M5 Junction 10 Improvements Scheme

Applicant Response to Interested Parties

TR010063 - APP 9.78

Applicant Response to Interested Parties Deadline 4 Submissions

ACTION 7 - DRAWING

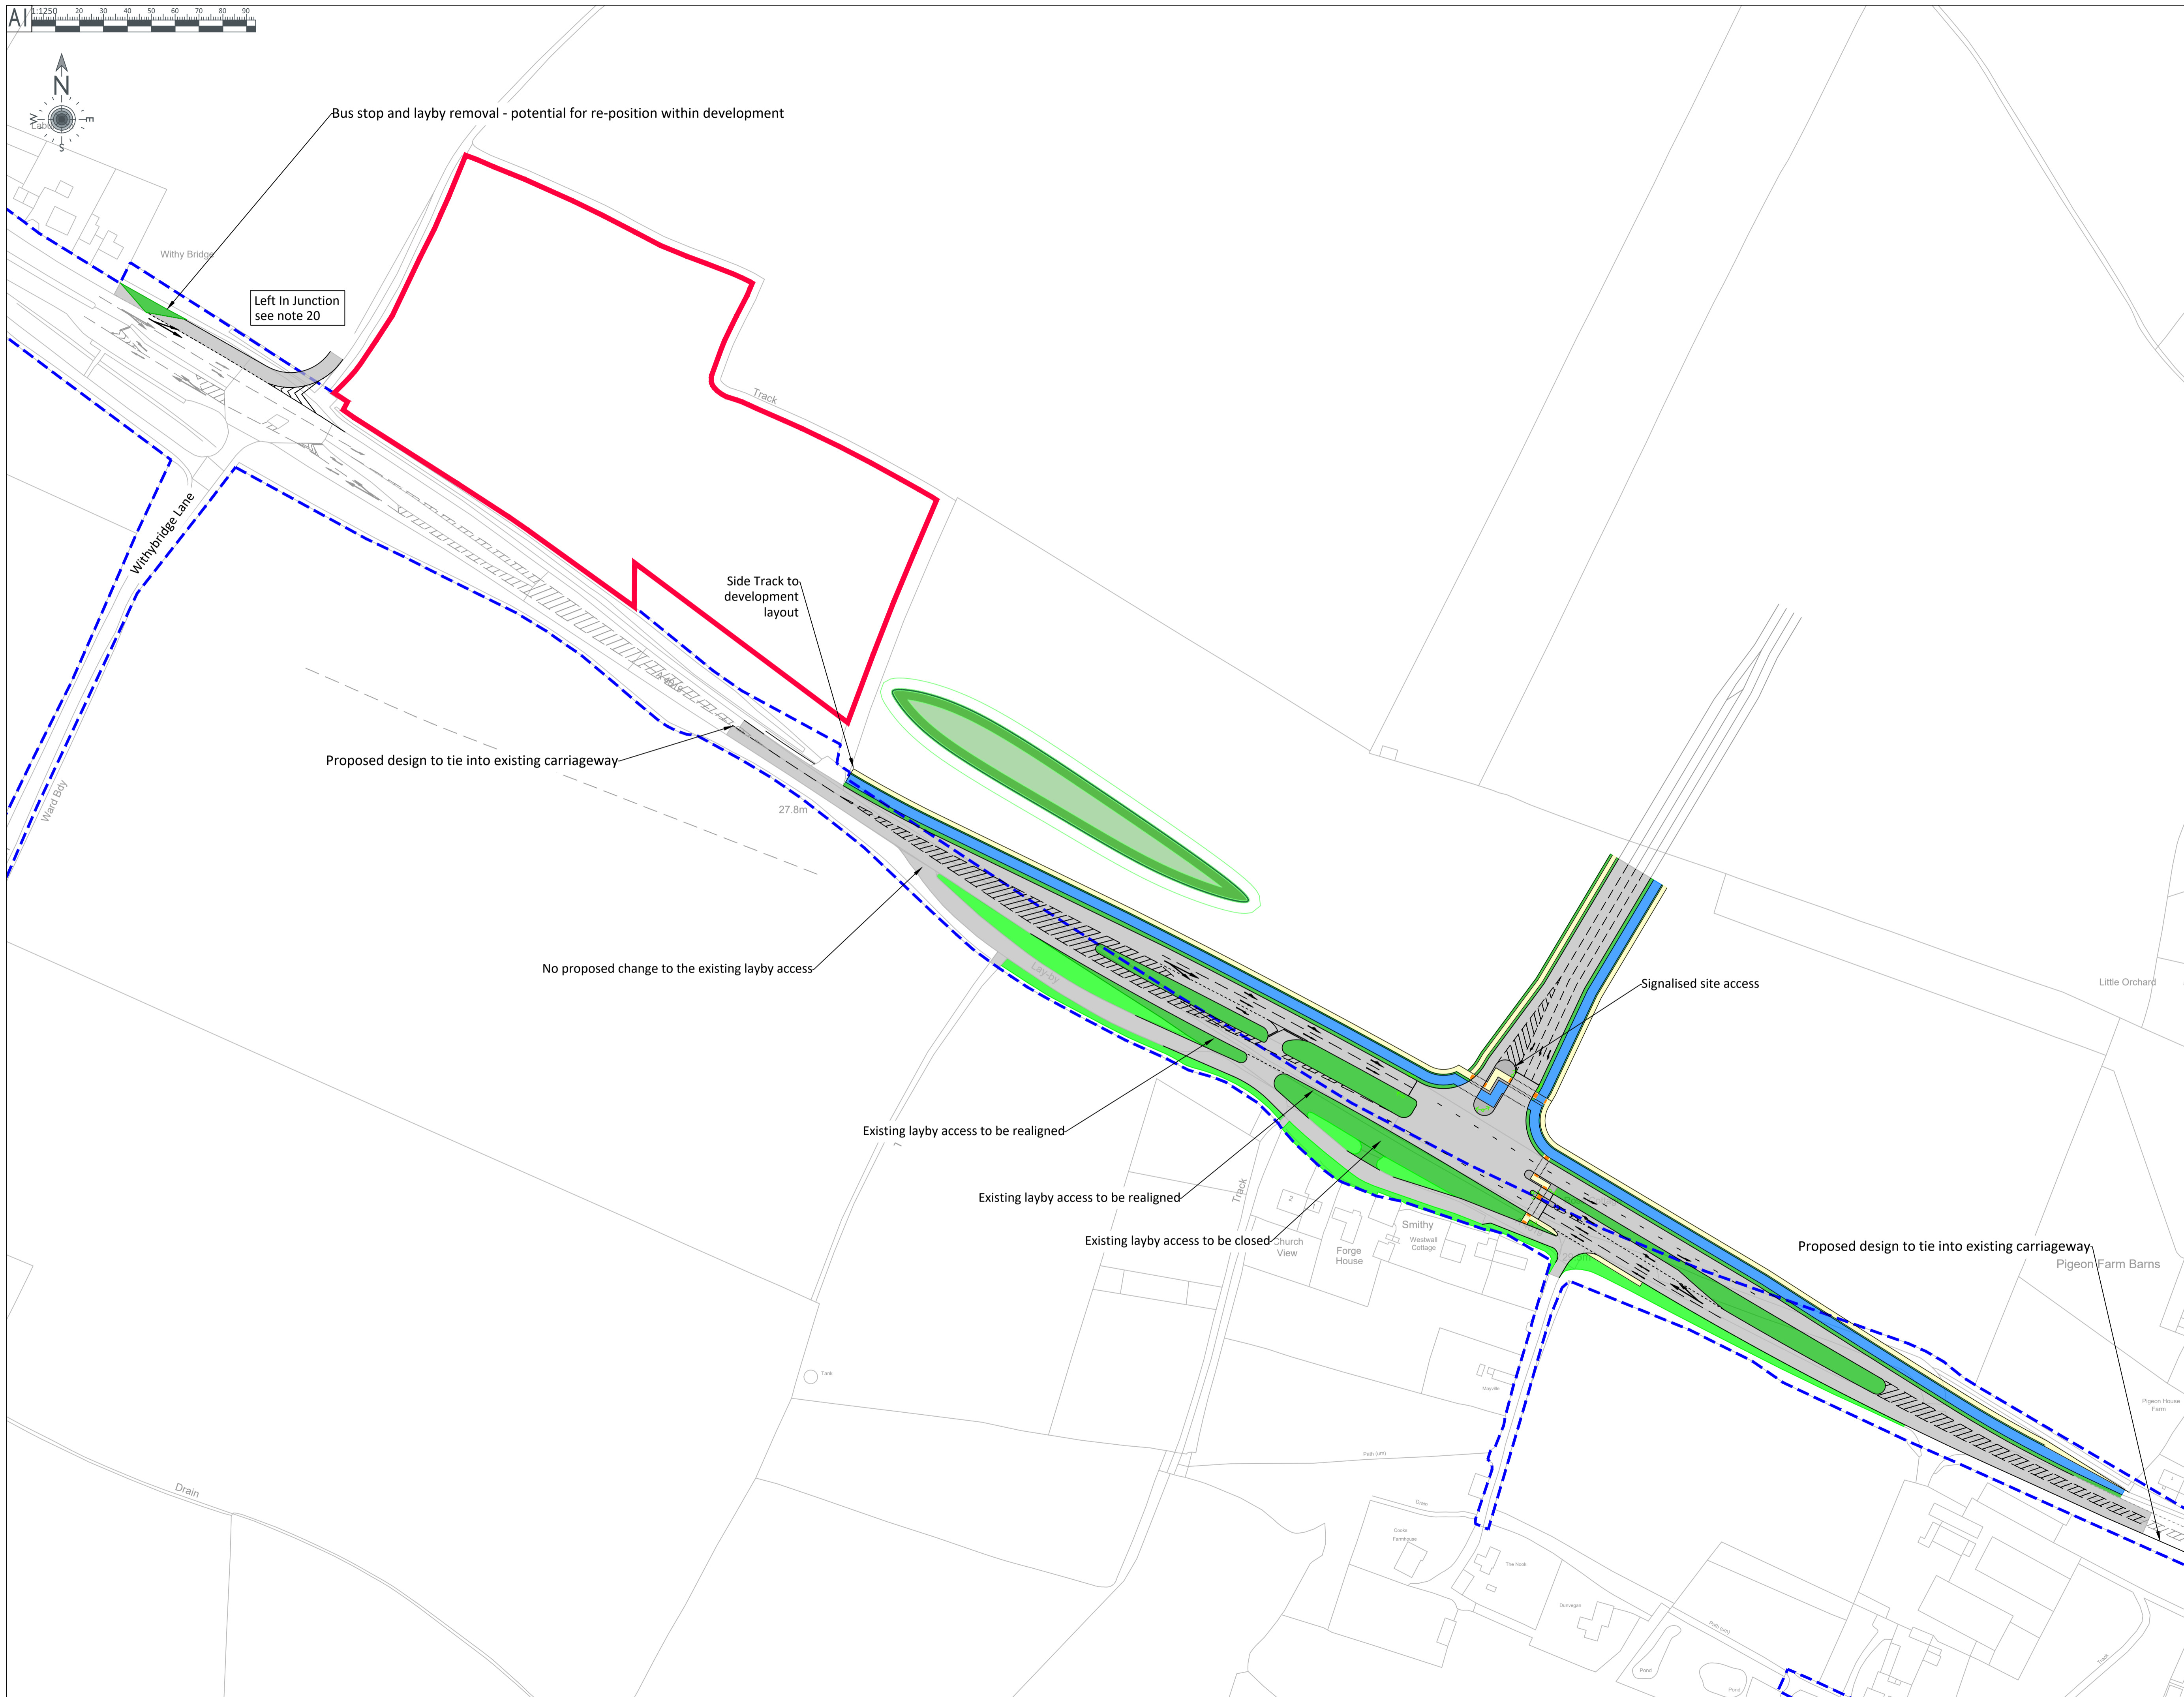
Response Reference	Issue	Applicants Response
ISH3 Item 4 Traffic and Transport Existing Access Arrangements		
045-01	<p>There are seven accesses into the Safeguarded Land north of the A4019 which are affected by the Scheme, labelled A – G below.</p> 	Please see Appendix B for Applicant’s combined response to Existing Access Arrangements.

Response Reference	Issue	Applicants Response
045-02	<p>Access A is an ungated track which connects from the merge of the A4019 slip road with Tewkesbury Road. It provides access to a traveller site adjacent to the M5. This access is not located on land within the control of Bloor Homes. The types of vehicles using Access A are unknown but likely to include large vans or smaller heavy goods vehicles.</p> <p>Access B is a field gate which joins the track forming Access A. The gate serves agricultural land which again is not located on land within the control of Bloor Homes. The types of vehicles using Access B are likely to include similar vehicle types to Access C (see below).</p> <p>Access C is an ungated track which adjoins the eastern end of the layby on the A4019. It serves the 'Bruton and Counsell' land of some 47Ha which is in arable crop rotations. It is the largest single land ownership within the Safeguarded Land and is within the control of Bloor Homes. It is the main access to this land and is in regular use for a wide range of agricultural machinery and articulated lorries (delivering fertiliser or removing straw). Agricultural vehicles access the land through a gateway that is currently 3.8m in width, but there is ample space at present to widen this – it should be noted that farm vehicles are increasing in size due to the need to achieve economies of scale, the largest widths at present are already 4m for current machines (as per John Deere combine harvester specifications). The gateway can presently be easily increased to accommodate larger vehicles by a small widening of the current access track, subject to the necessary permissions.</p> <p>Access D is an ungated track which immediately adjoins Access C. It is owned by Gloucestershire County Council and is in agricultural use. Usage is likely to be similar to Access C.</p> <p>Access E is a gated vehicle crossover from the A4019. It is a strip of land which continues north into the Bruton and Counsell land, serving as a secondary access which is important in that it allows an alternative if there is a traffic issue near the M5 junction and a need to go an alternative way back to the farm yard/grain stores etc. From the strip of land, a further gated access is provided on the eastern side. This provides access into the Carter owned land</p>	<p>Please see Appendix B for Applicant's combined response to Existing Access Arrangements.</p>

045-04	<p>A vehicle tracking drawing has been provided by the Applicant of the combined farming access which highlights a vehicle track for a tractor and hay wagon with a length of 19m and width of</p> <p>However, this does not meet the landowner's access requirements for the following reasons:</p> <ul style="list-style-type: none"> (a) Farm machinery is wider than the design vehicle used and is typically in excess of 3m wide (noting also that vehicle sizes are increasing as indicated above). (b) At peak times the combined access track will be frequently used – each landowner may have 4 – 5 tractor rigs towing machinery in order to ensure constant take off from a combine harvester. <p>Inevitably therefore at certain times there would be conflicts between multiple oncoming vehicles in this area. It has not been shown that two vehicles towing machinery exceeding 3m width could pass within the access road. This could</p>	<p>Please see Appendix B for Applicant’s combined response to Proposed Access Arrangements.</p>

Response Reference	Issue	Applicants Response
	then result in conflicts within the signalised junction arrangement and in particular vehicles being 'stuck' within the junction.	
045-05	It is the landowner's view that access to its land should be provided via a direct north-south road from the junction, as opposed to the current arrangement which provides a tight corner radius which will cause operational and safety issues at peak times.	Please see Appendix B for Applicant's combined response to Proposed Access Arrangements.
045-06	This is a genuinely held view from a farm operations perspective. Although the existing access gates are simple, each landowner is able to access its land independently. With the Scheme as proposed, this will be shared via a narrow track, and there is a risk of conflict between oncoming large machinery.	Please see Appendix B for Applicant's combined response to Proposed Access Arrangements.
